**From:** [Brendan M Hurley](#)  
**To:** [Bruce Zhang](#)  
**Cc:** [Fire Safety](#)  
**Subject:** Oakdale West Estate (SSD-7348-Mod-5). BFS20/2405  
**Date:** Wednesday, 12 August 2020 13:52:34

**Oakdale West Estate (SSD-7348-Mod-5)**

FRNSW have reviewed the documentation provided as part of modification 5, Modification to SSD 7348 including amendments to the Concept Proposal and Stage 1 development including changes to Precinct 1A layout, Stage 1 development dangerous goods quantity, Biodiversity Offset Site, noise wall completion timing.

**Figure 7-1: DG Storage Areas**

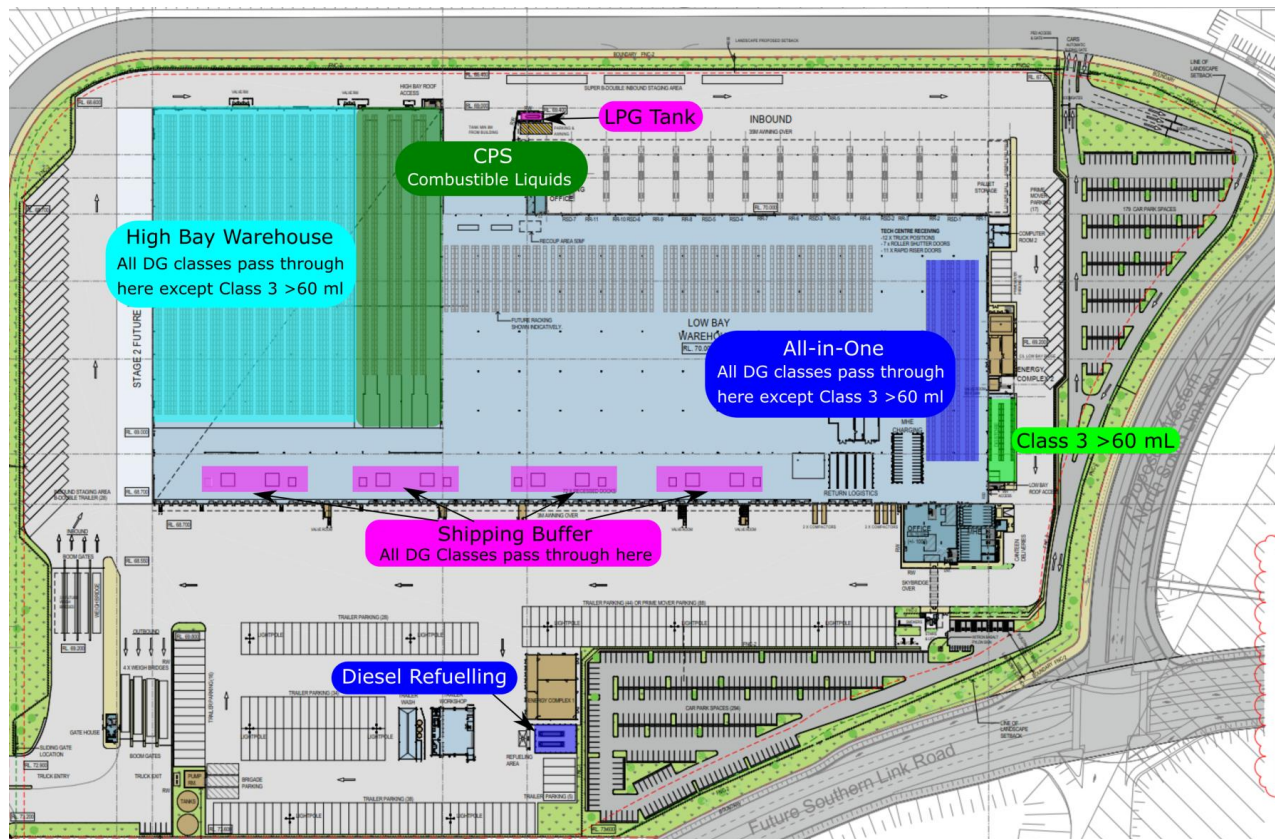
- Consideration be given to the provision of cages/mesh protection for the aerosols stored within the racking system of the high bay warehouse area. *SafeWork NSW – Storage and Handling of Dangerous Goods Code of Practice 2005 - 4.3 Storage and handling of packages “where an aggregate volume of 100 L or more (or 50 kg or more) of aerosols or other types of small disposable cylinders are stored together, enclose the storage area (for example with mesh) to reduce the risk of projectiles in the event of a fire”* Cage's for stored aerosols.
